Our Ref: 23022022_RtS_Biodiversity2022

23 February 2022

RE: Major Projects – Eraring Battery Energy Storage System (SSD-15950052)

I refer to the document dated 15 December 2021 entailing the recommendations from Biodiversity and Conservation Division (BCD), with our responses in italics as follows.

FIGURE 1.2
Development Footprint

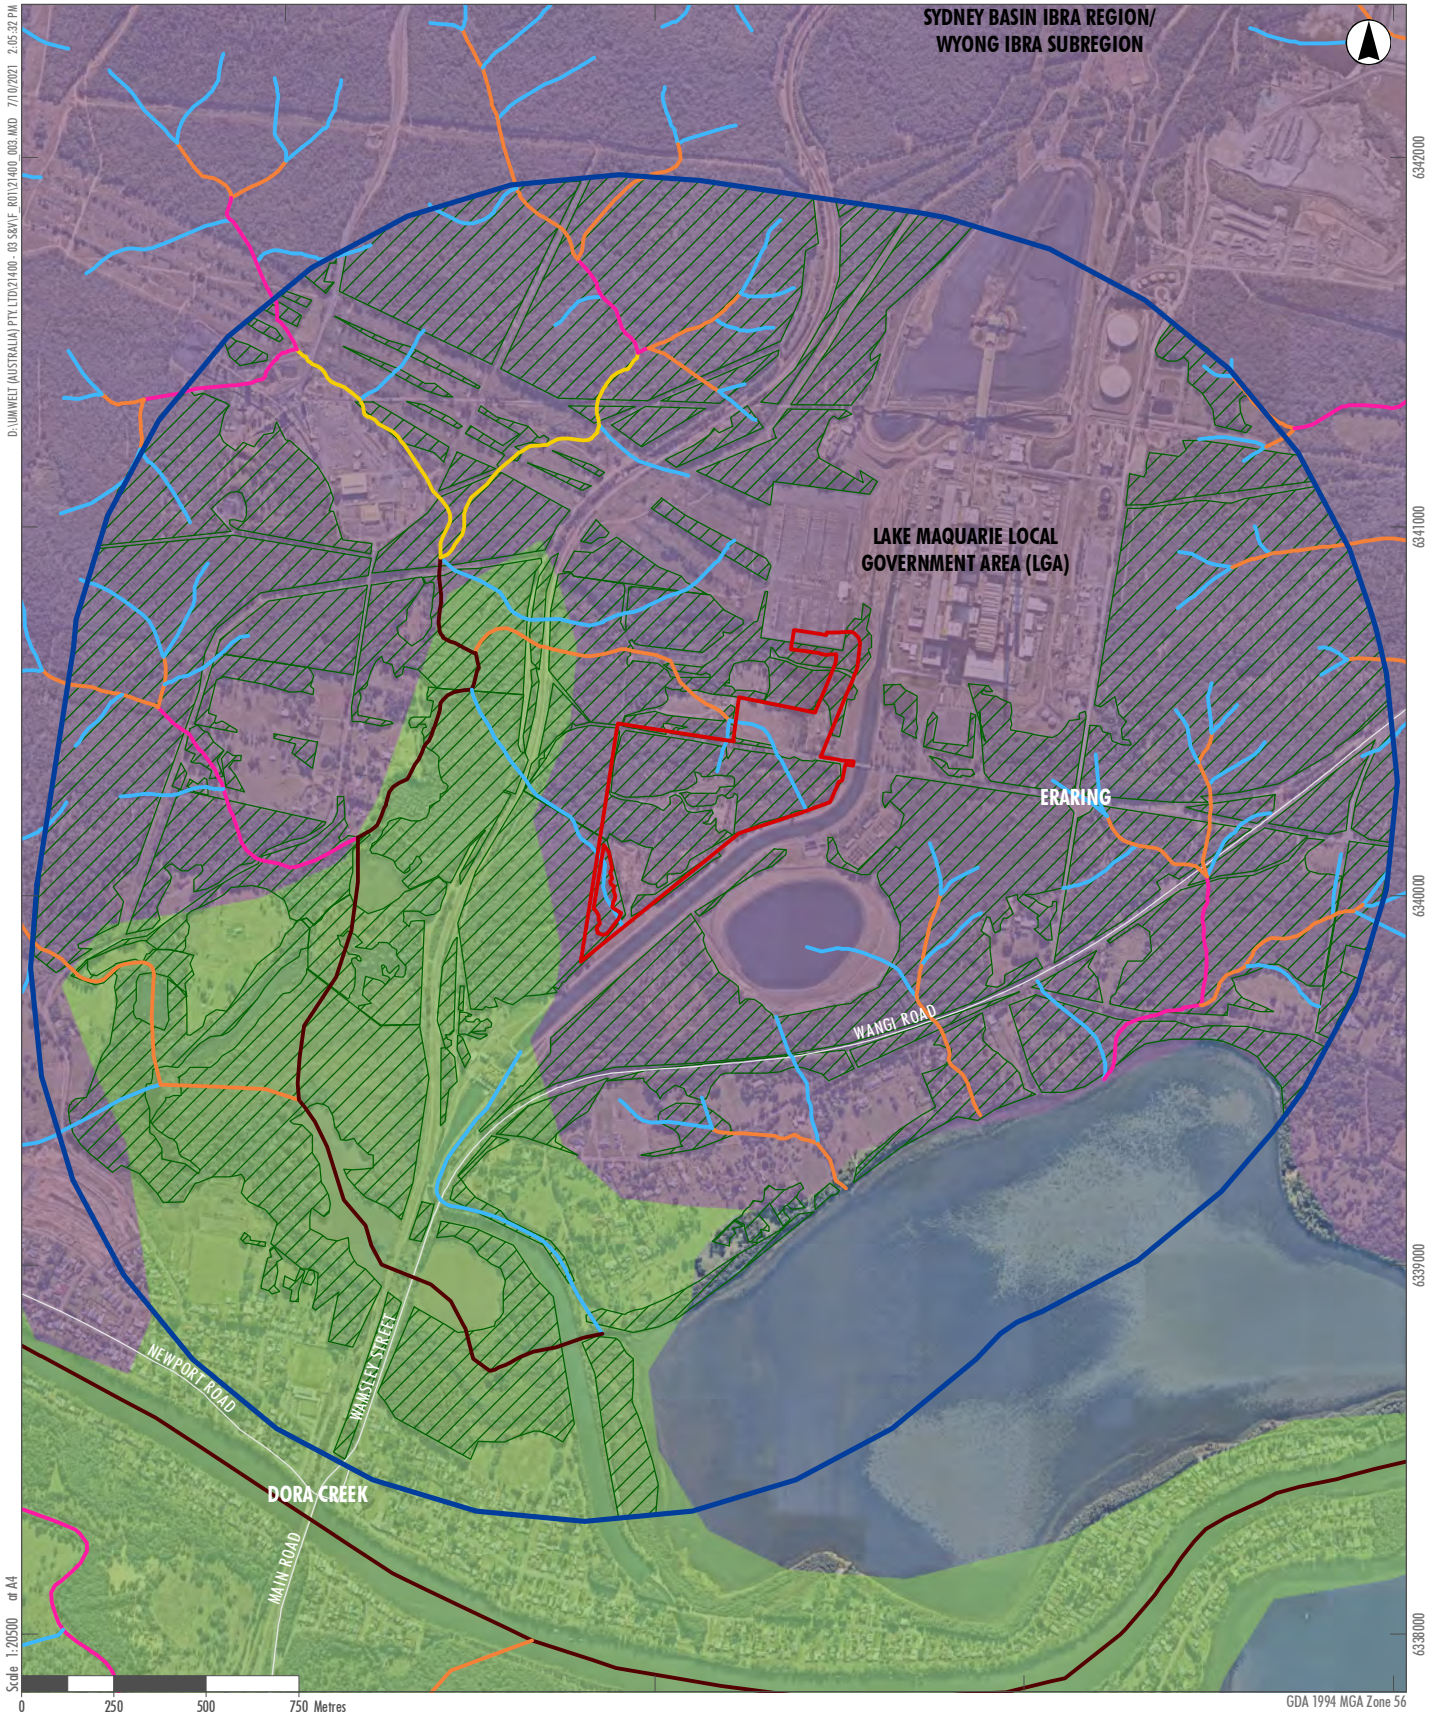
6. The accredited assessor needs to demonstrate what actions and measures they have undertaken to avoid the direct and indirect impact on swift parrot important habitat mapping. BCD recommends the development footprint is redesigned to cover the more disturbed areas of the site and avoid the important mapped areas for the swift parrot.

Addressed in BDAR Section 5.3 with additional wording and figure showing large area of swift parrot habitat avoided within EPS landholdings.

*While a small area (3.1 ha) of swift parrot (*Lathamus discolor*) mapped important habitat is proposed to be removed, this represents a very minor area of important habitat mapped within the EPS landholdings, being a total of 306.3 ha (refer to Figure 5.1. of BDAR). The area to be removed therefore represents 1% of this mapped habitat and this is the habitat within EPS- owned land alone. Swift parrot important habitat mapping extends outside this area in the locality also, and therefore the total to be removed would be less than 1%.*

If the Development Footprint was placed anywhere else on EPS- owned land, it would in fact remove more swift parrot habitat (refer to Figure 5.1.).
